Application Correspondence "Notification of Withdrawal"

From: Myles [REDACTED]
Sent: 20 April 2021 20:34
To: Simon Davis <Simon.Davis@arun.gov.uk>
Subject: Re: Planning Ref: BR/81/21/CLE

Proposed - Ground Floor

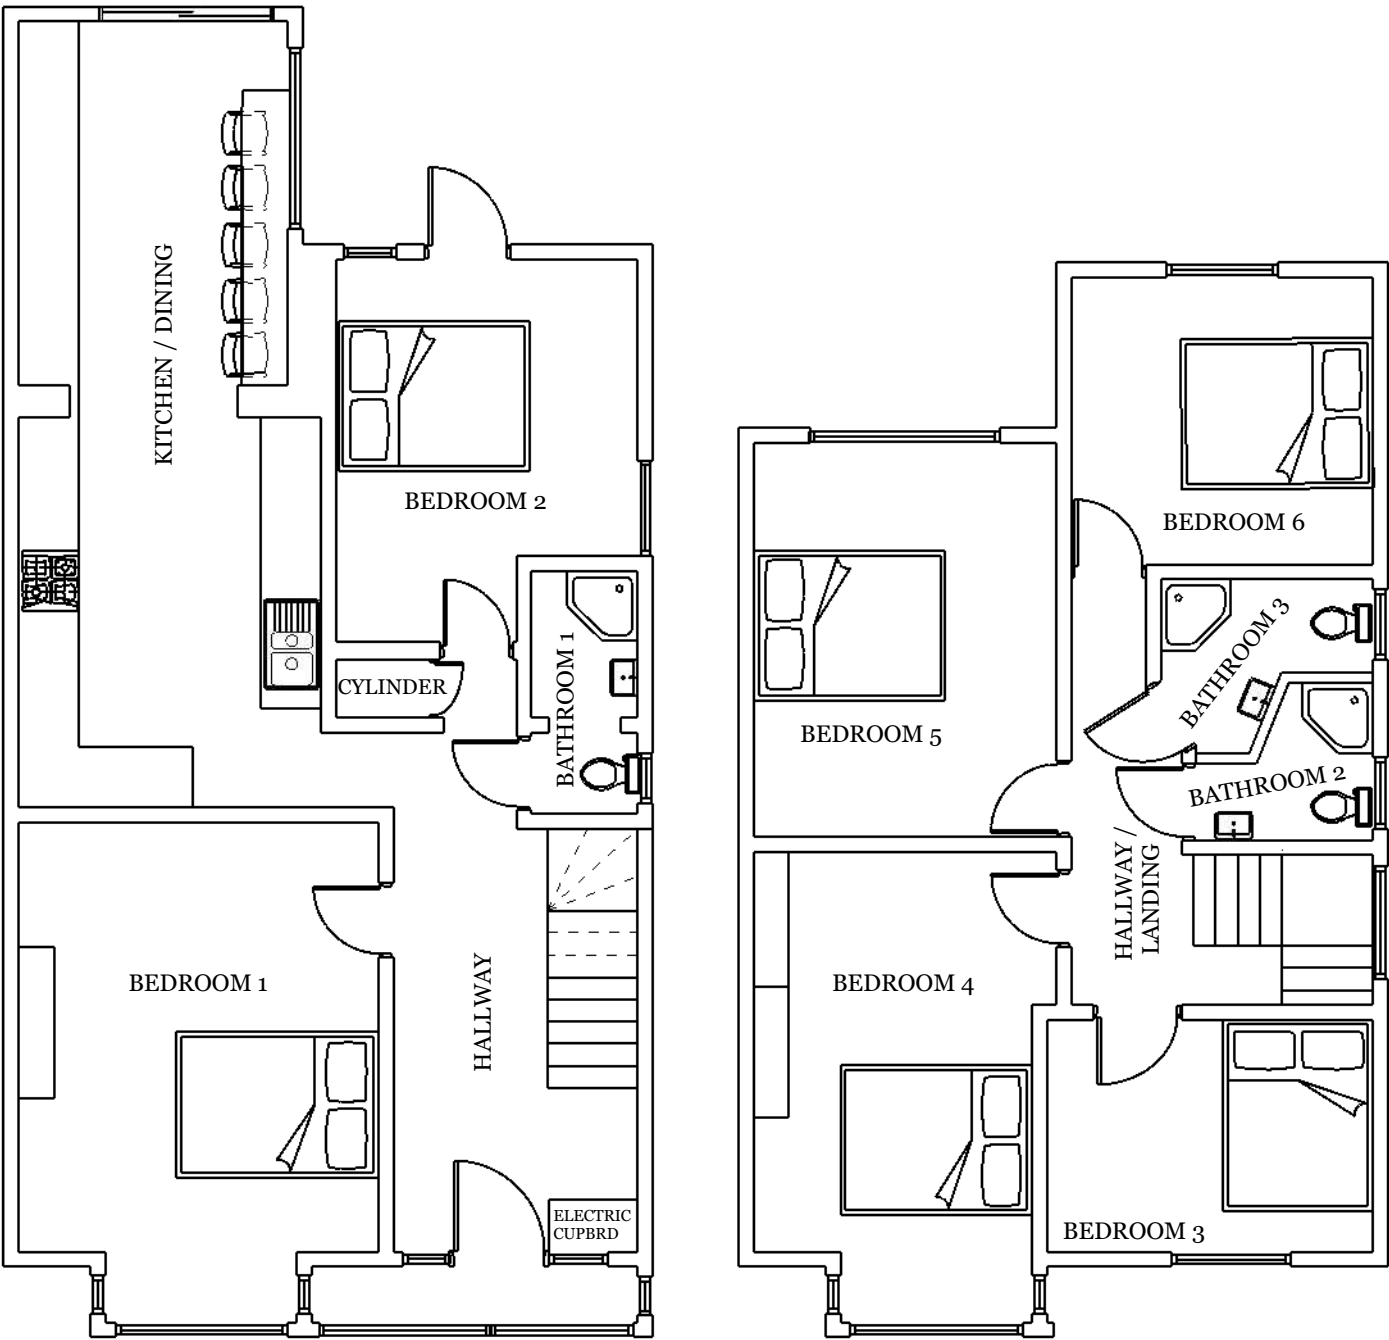
I am currently your case officer although this may yet be reallocated to an alternative officer. However, in the meantime, I have been contacted by our Environmental Health Officer (EHO) who has asked if you can confirm how many occupants you intends to have as tenants in this property please? We note that the application is for a 6 bedroom HMO but the floorplans also appear to show double beds in all rooms. The EHO also asks that you provide room sizes in m2.

Please also note that our system does not allow us to electronically scale from 1:75 plans. Those in the following screenshot are the only options we have. Would it be possible to provide a new floorplan in a different scale and then also annotate/provide a key with the room sizes.

Proposed - Ground Floor

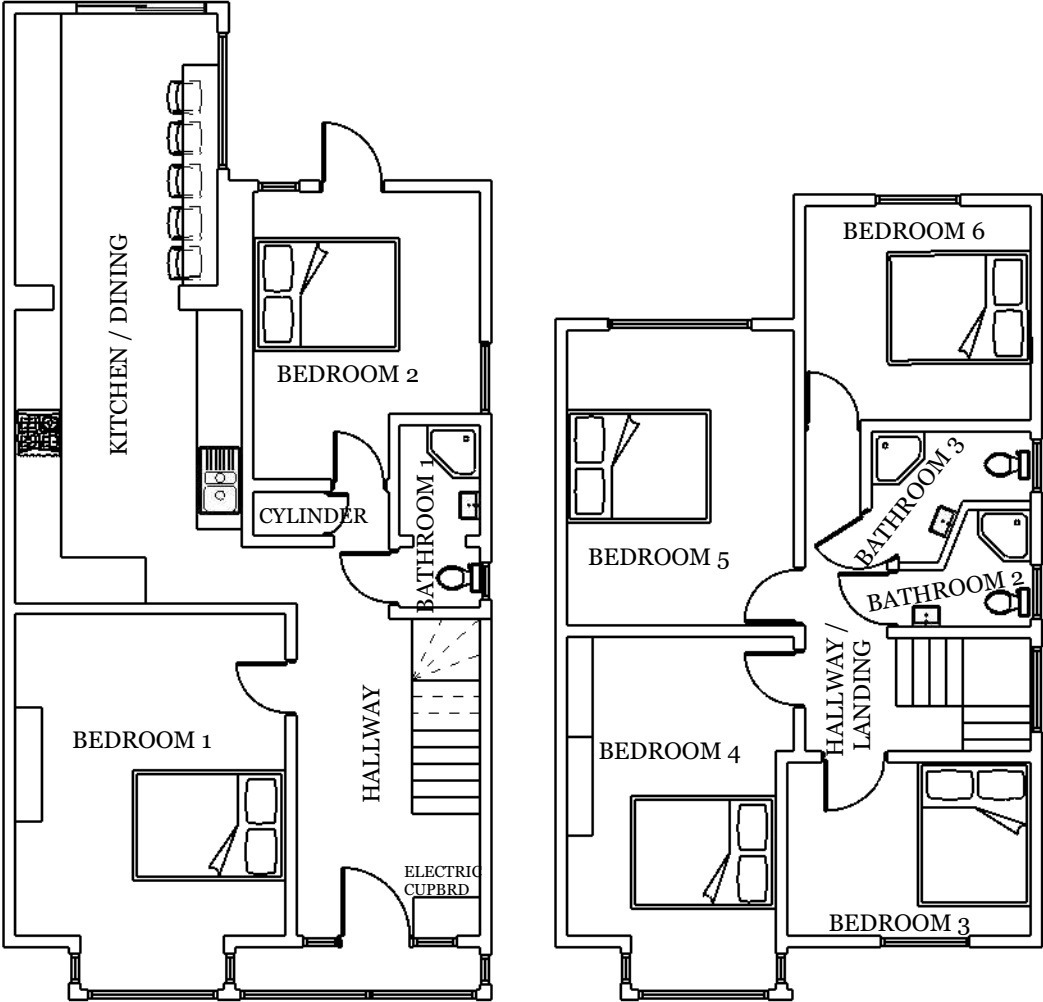
To correct the scale, the drawing would need to be re-drawn at a different scale – at say 1:50 or 1:100. This would then allow us to measure the rooms and work out the floor areas.

I think I have attached the drawing in the correct scale now.
